WRITTEN REPRESENTATION

East Pye Solar - Planning Inspectorate Reference EN0110014

To: The Examining Authority, The Planning Inspectorate

Date: 11 September 2026

Sources: Esri, TomTom, Garmin, FAO, NOAA, USGS, © OpenStreetMap contributors, and the GIS User Community

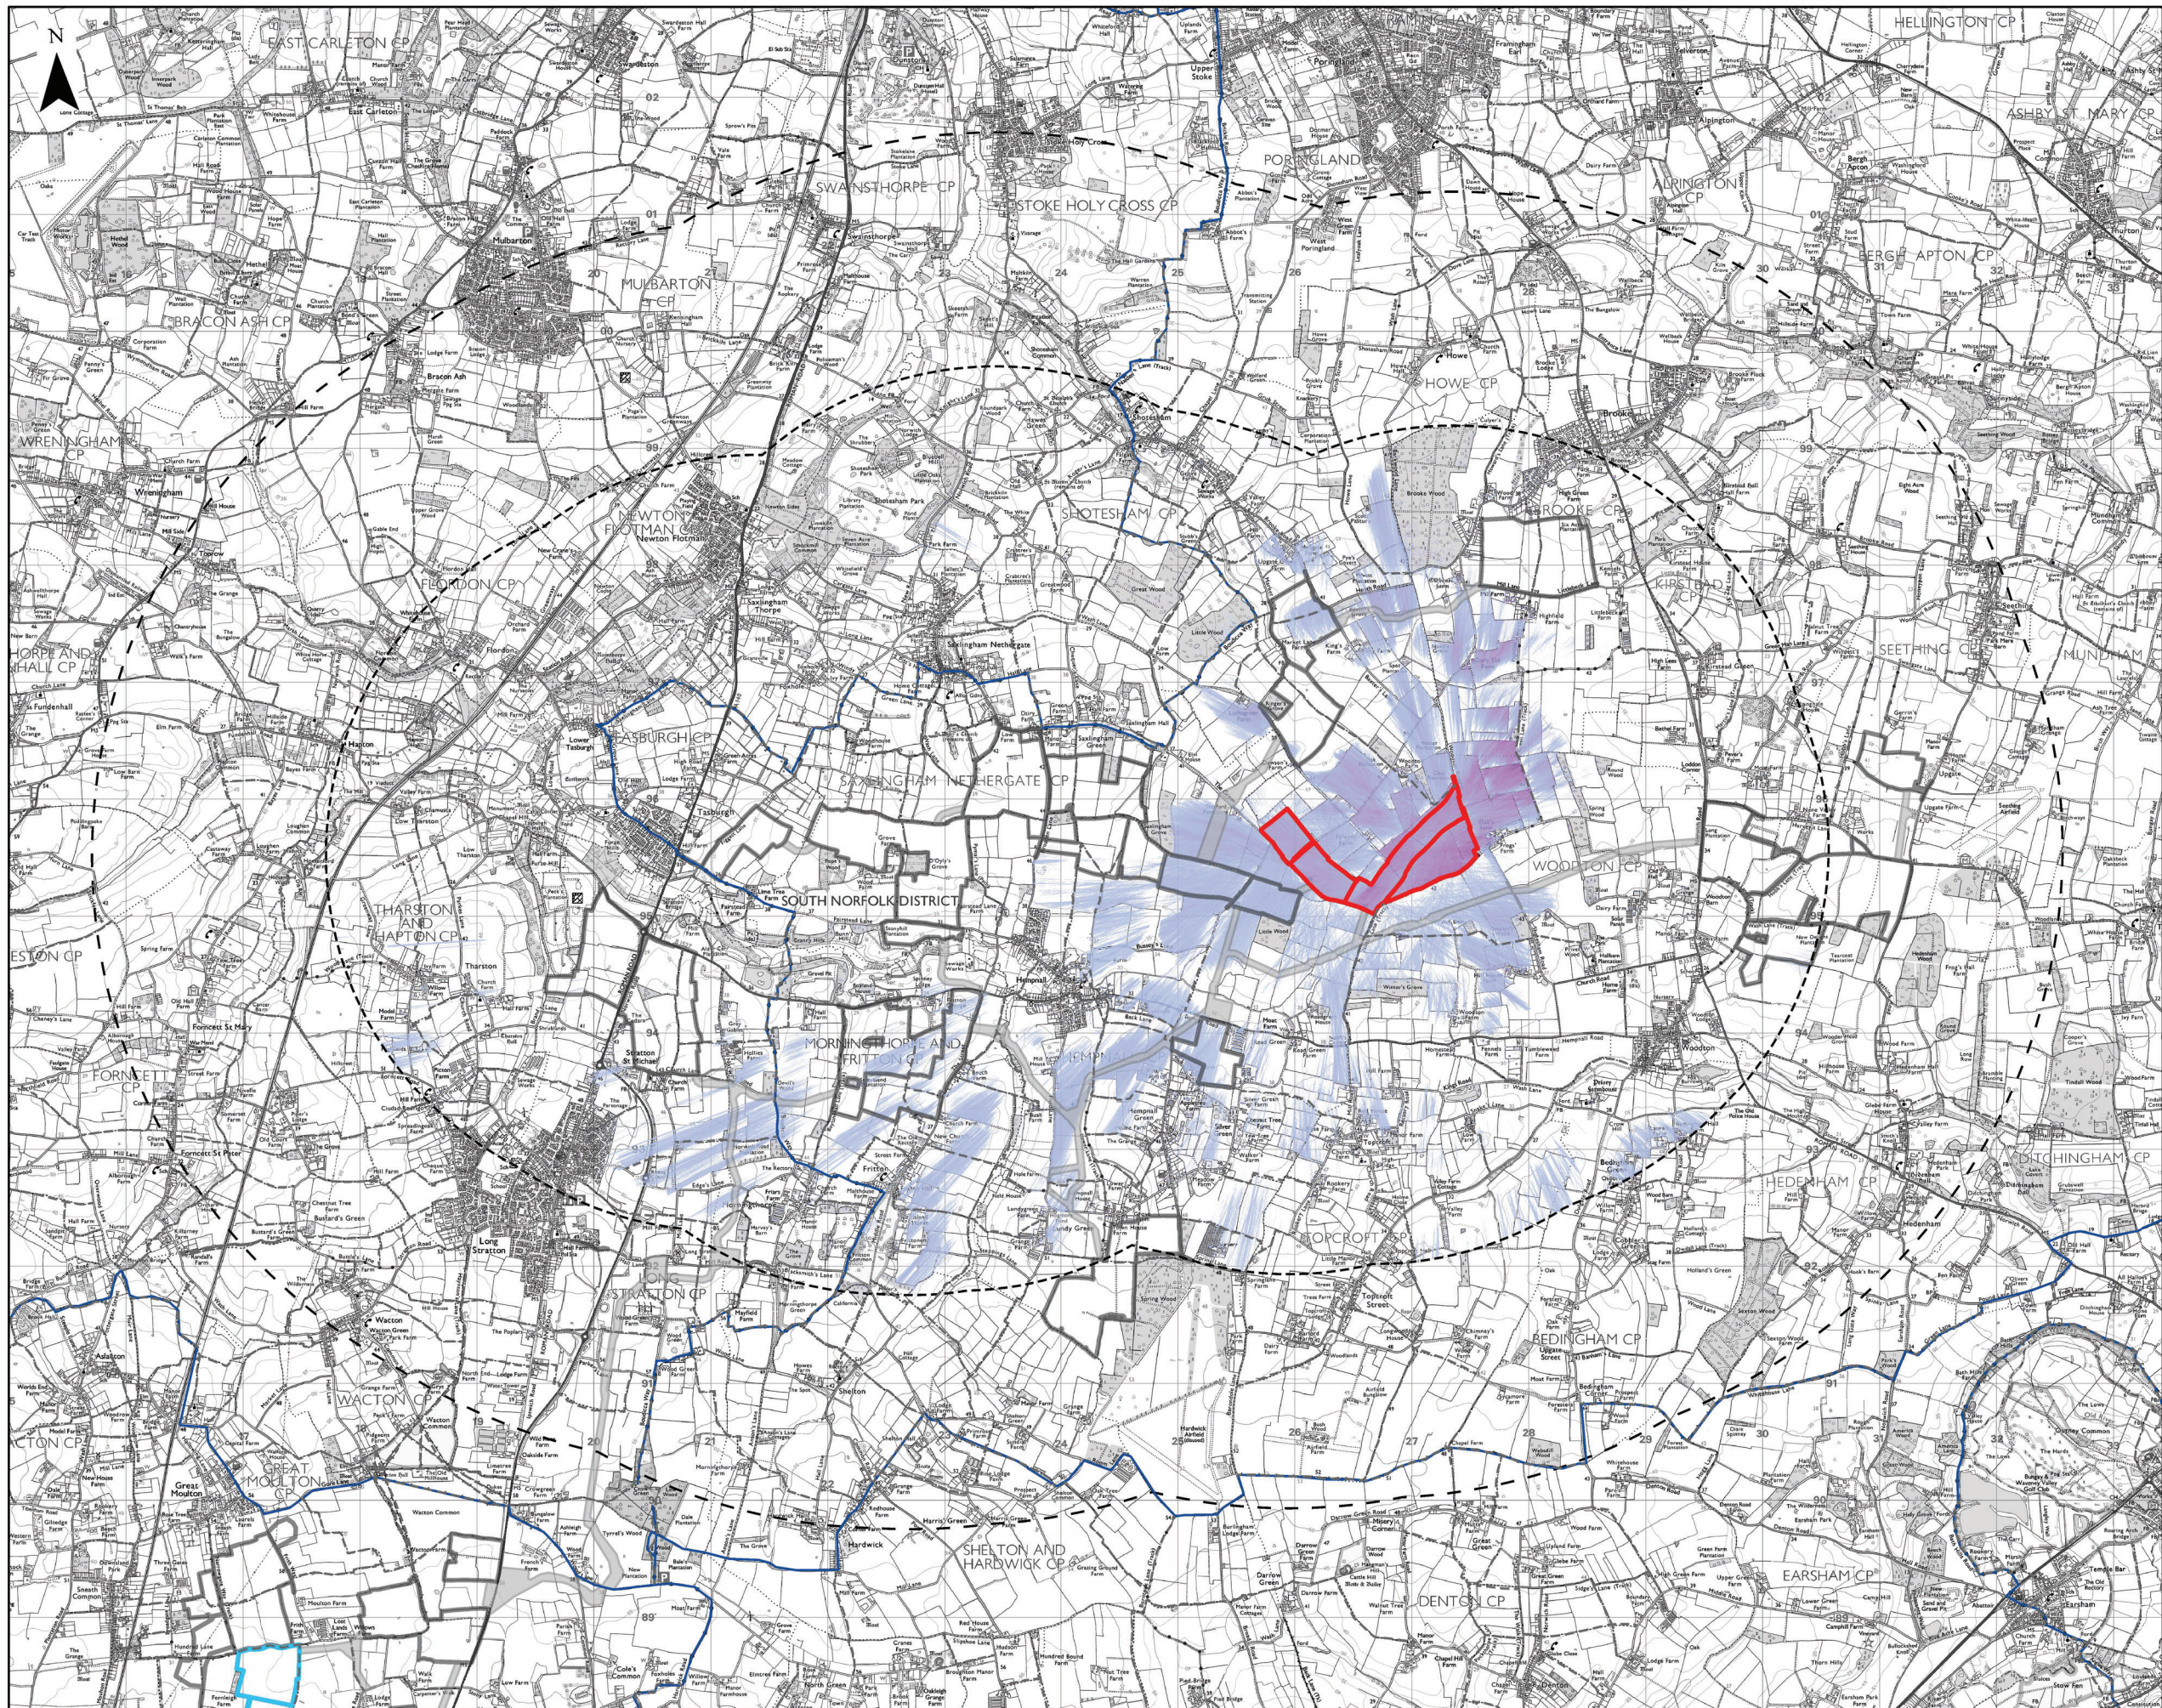
We therefore request that the Applicant be required to confirm whether **Church View Barn falls within the ZTV for Site 8 (Figure 7.5.4) and Site 7 (Figure 7.5.5)** and, if so, to explain why it has not been assessed as a named or representative residential receptor.
